Our Ref: 17068
Council Ref: SSDA 8517 & SSDA 8449

RE: SSDA 8517 - Response to Comments on Proposed Amendments to Bays 1-4a and Public Domain

Proposed Plan Locomotive St

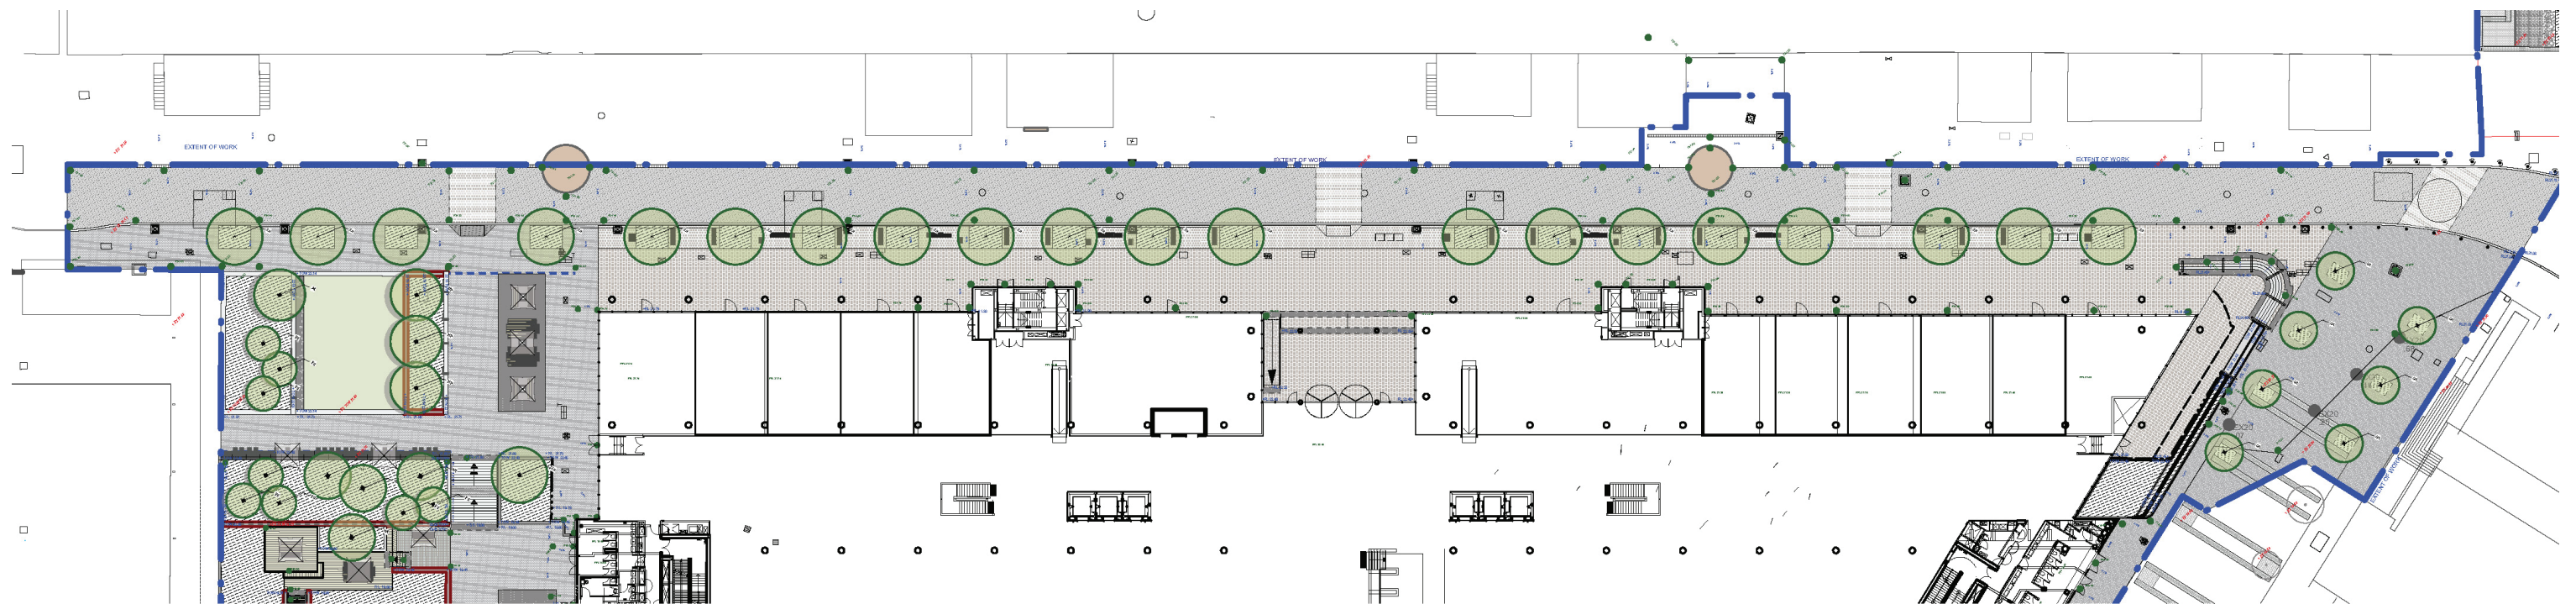
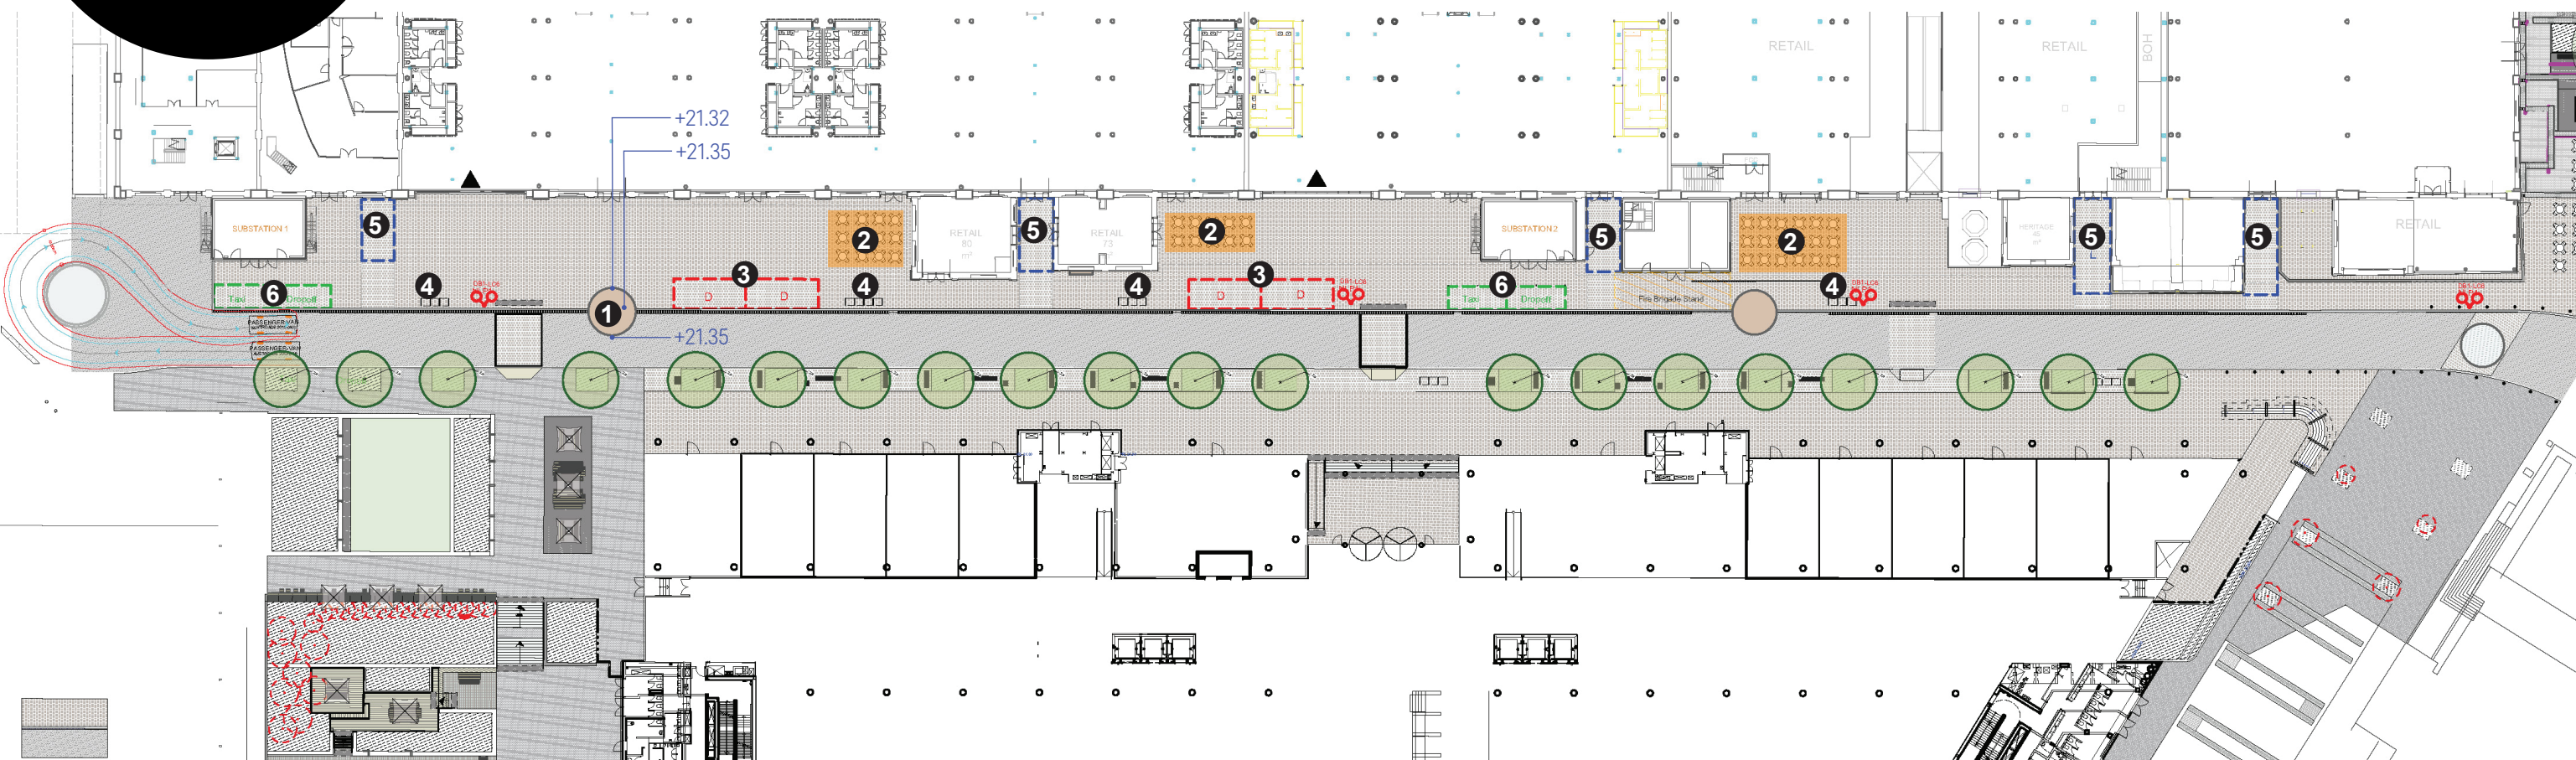
With respect to the parking changes along Locomotive Street, the associated ASPECT Studio document has numerical discrepancies on page 11 and page 19. The numerical figures should be consistent across the documents.

The numerical discrepancies within the Public Domain Plan package, prepared by Aspect Studios were picked up during the review of the draft conditions and a revised package were submitted with the Response to Draft Conditions letter, dated 4 October 2018. However, for ease of reference the Public Domain package is included at **Attachment B** and all the changes to the plans are now clouded.
